## **APPEAL STATEMENT OF CASE**

| <b>Planning Inspectorate Reference:</b> | APP/T2350/W/23/3325434 |
| <b>LPA Application Reference:</b>       | 3/2023/0226            |

**Prior notification application for the proposed conversion/redevelopment of two agricultural buildings into two dwellings**

EXISTING SITE PLAN

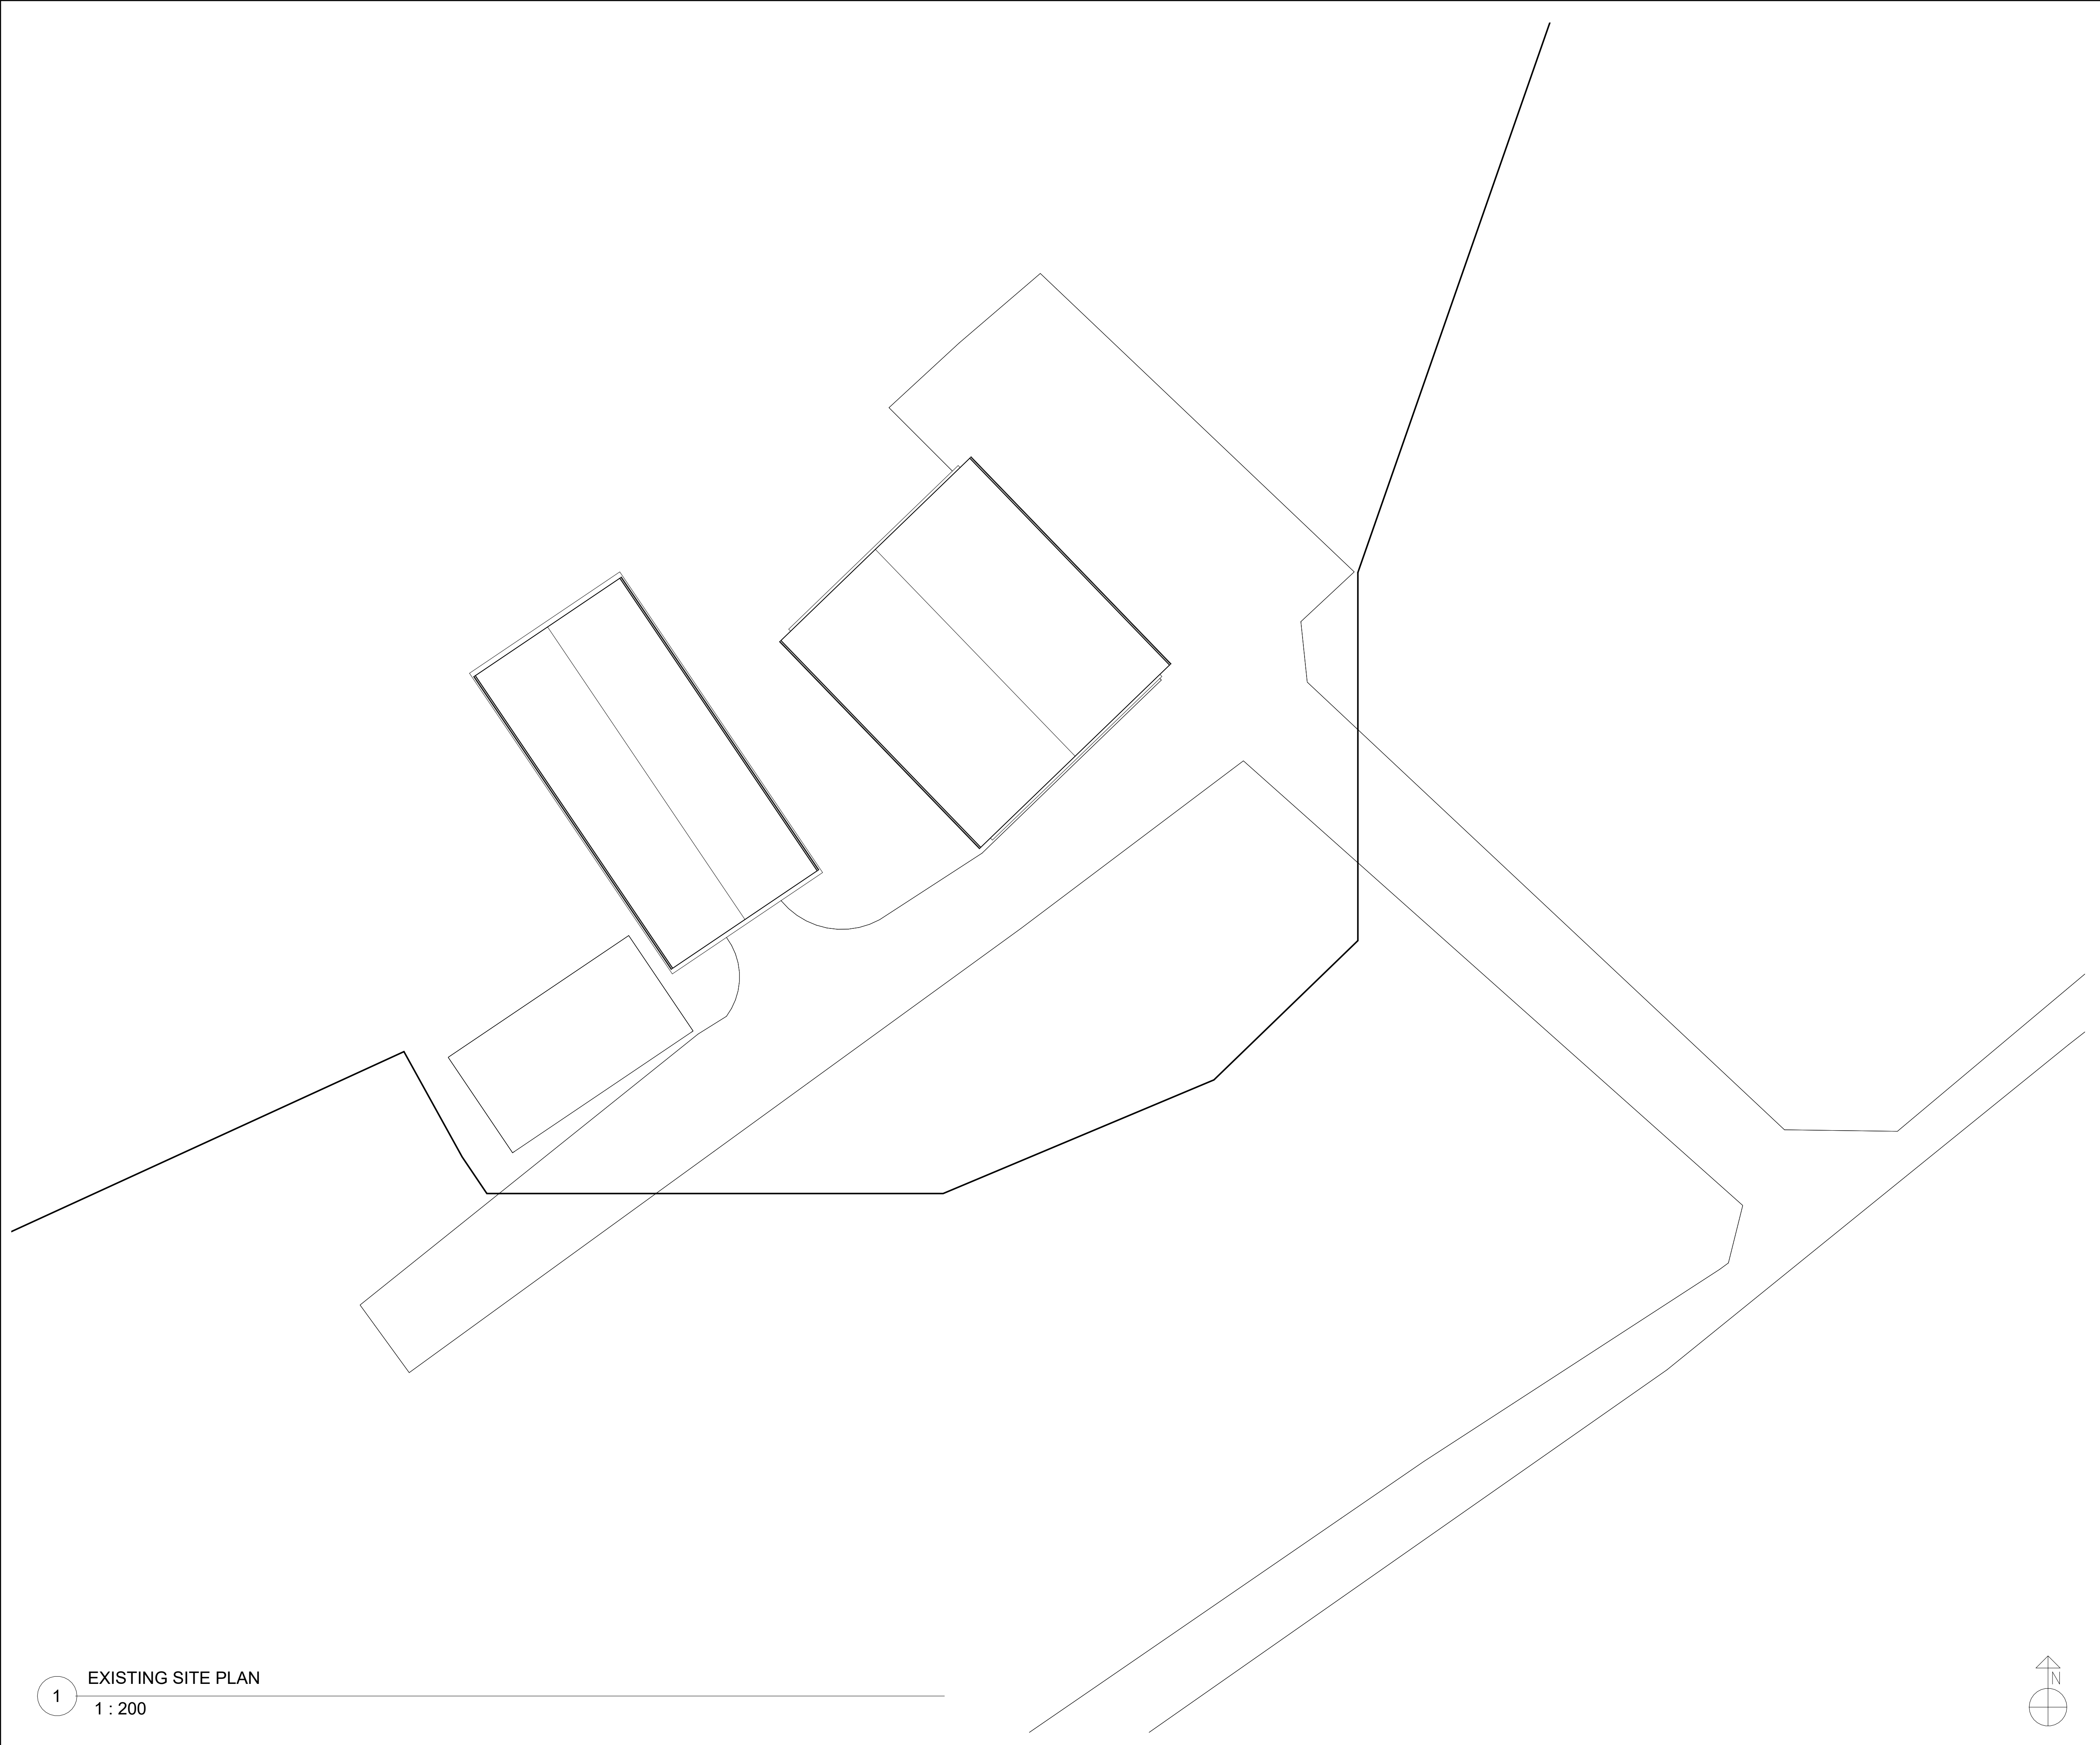
- 7.1 The main issues for this appeal relate to whether the building operations required to facilitate the change of use are reasonably necessary; whether the design and external appearance of the resultant buildings is acceptable; and impacts on ecology.
- 7.2 The existing site plan A1.1 submitted with the application indicates the access and areas of hardstanding and this is not disputed. However, the proposed site plan A1.2 and proposed floor plans A2.2 indicates that retaining walls along the southern edge of the two units would

SHEET:
PROPOSED FLOOR PLAN

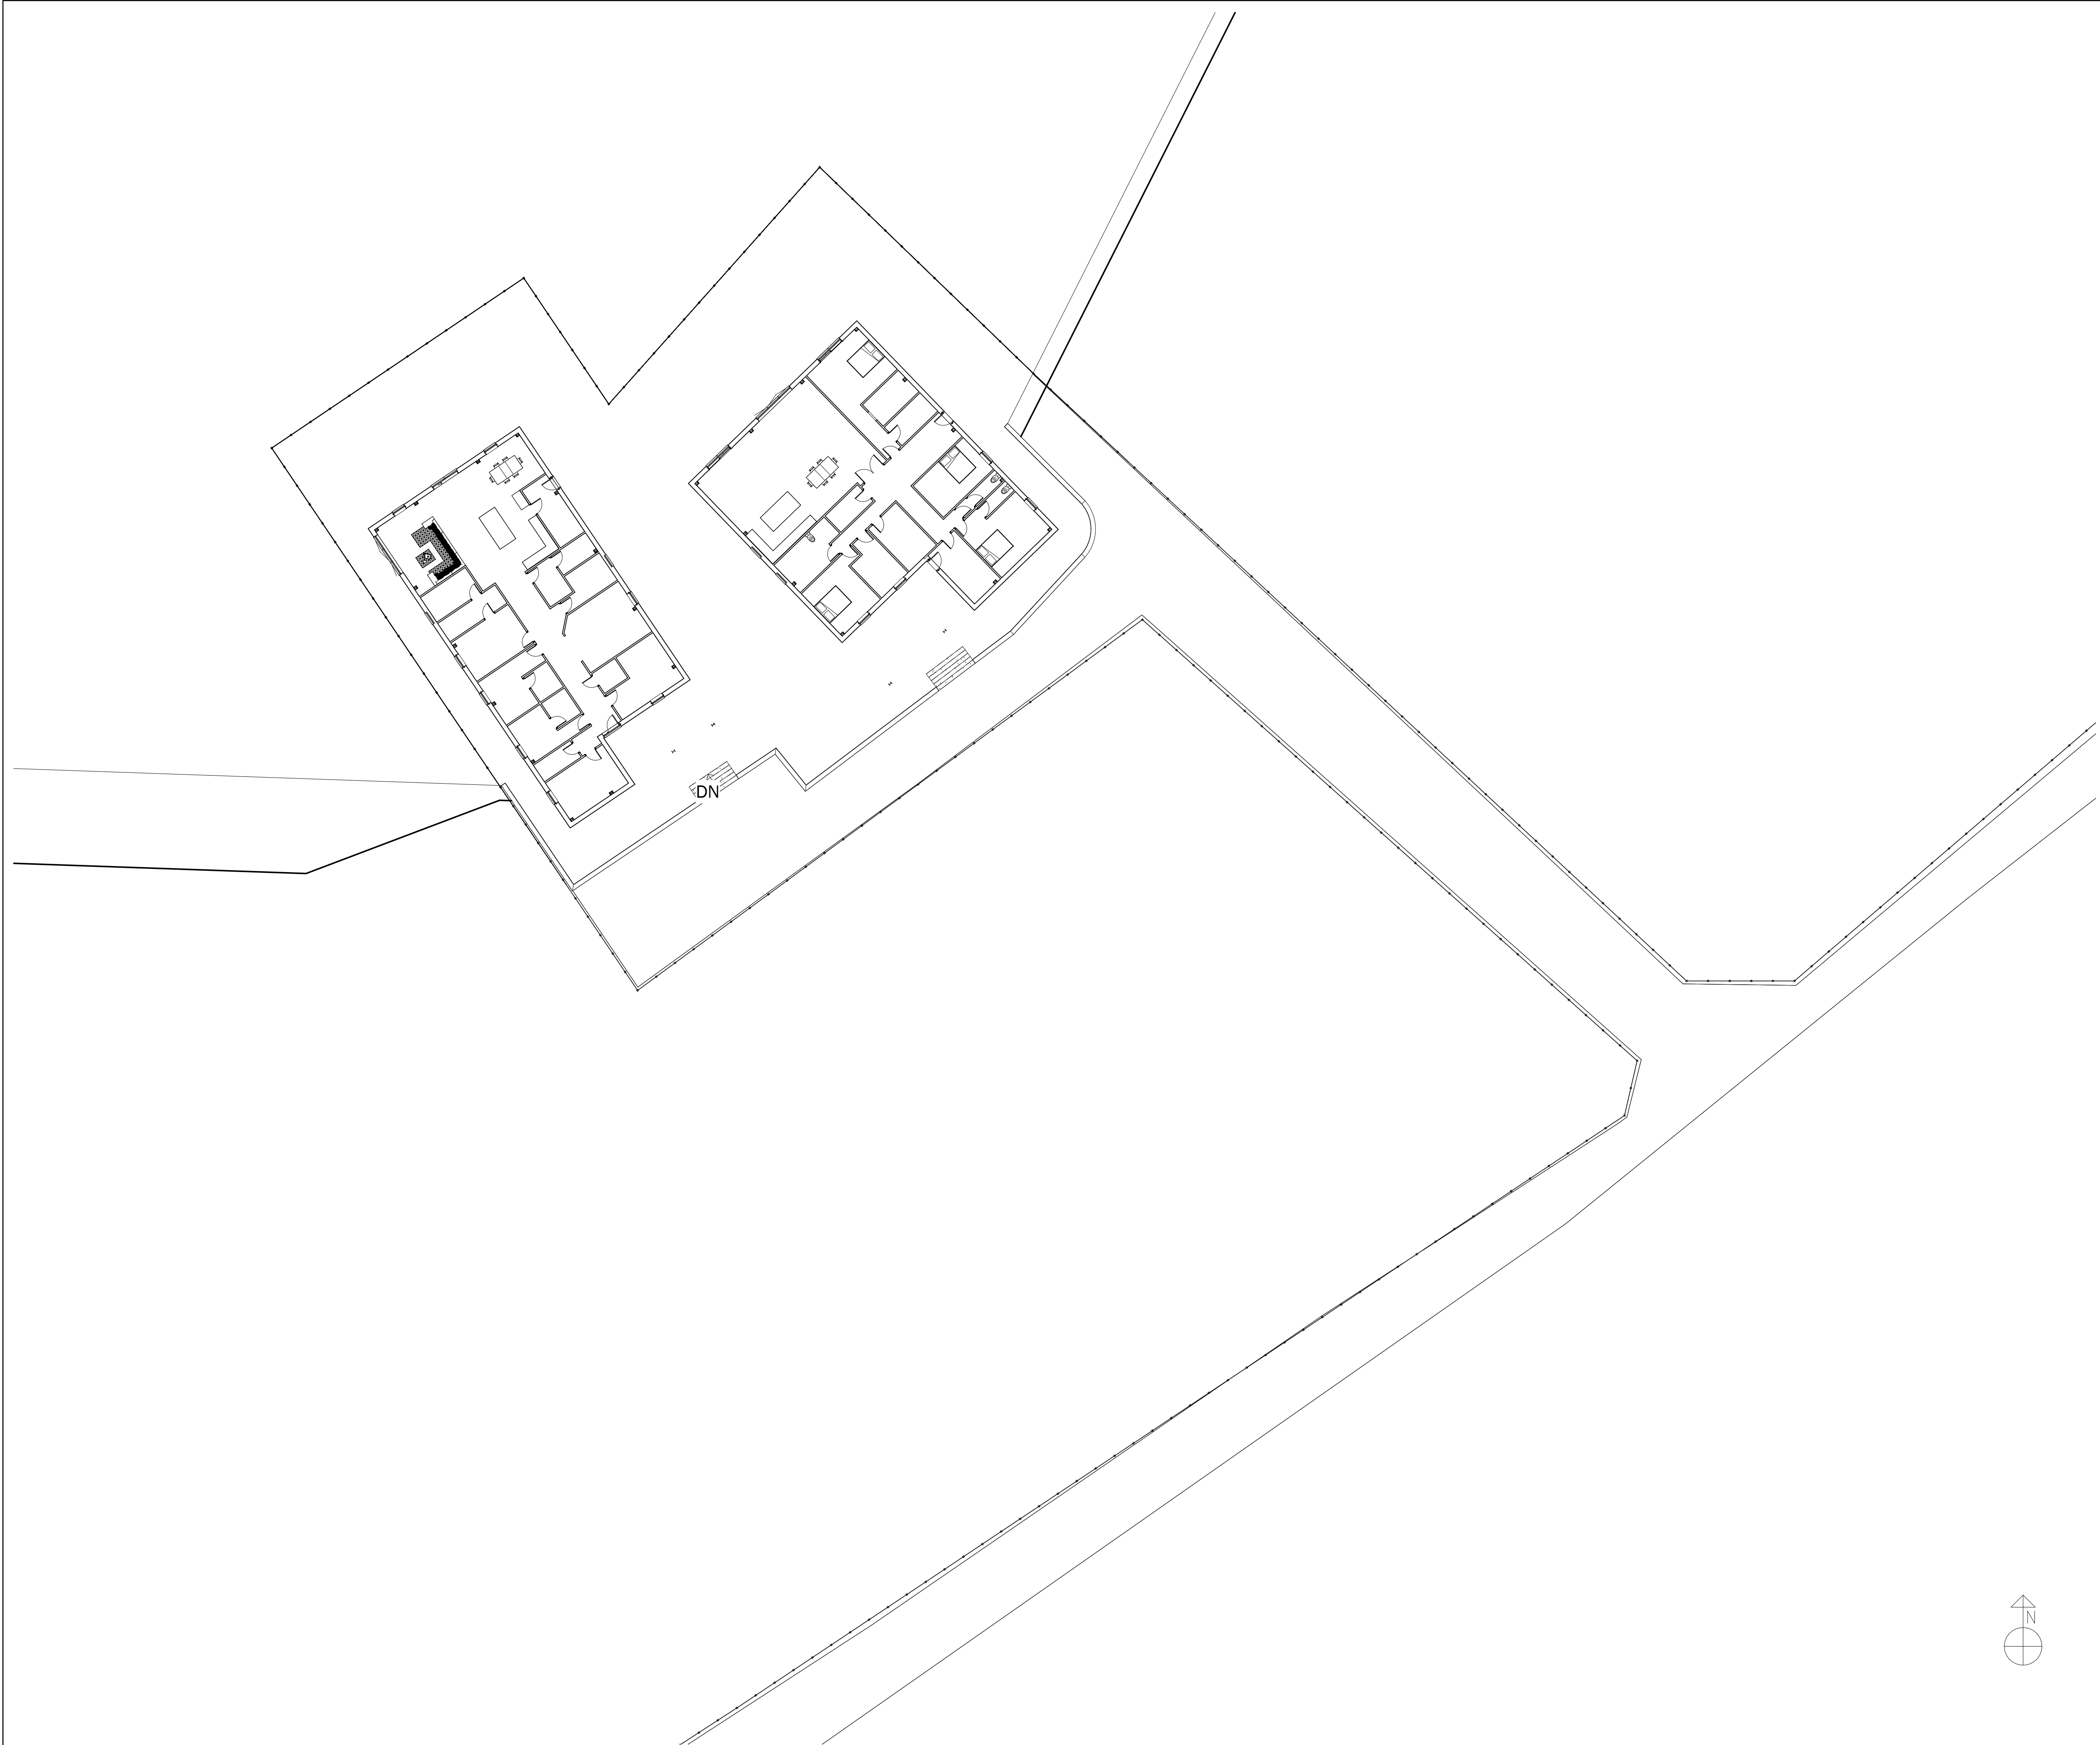
be formed together with five wide steps leading down to the southern entrance of both buildings. Existing and proposed site plans (A1.5 and A1.6) have been submitted with the Appeal showing spot levels remaining the same. However, as mentioned the steps and retaining walls clearly shown indicate that the land form will be changed with the introduction of retaining walls and steps down to both units. This is also illustrated in the visuals submitted. These engineering works are considered to go beyond the realms of reasonably necessary.
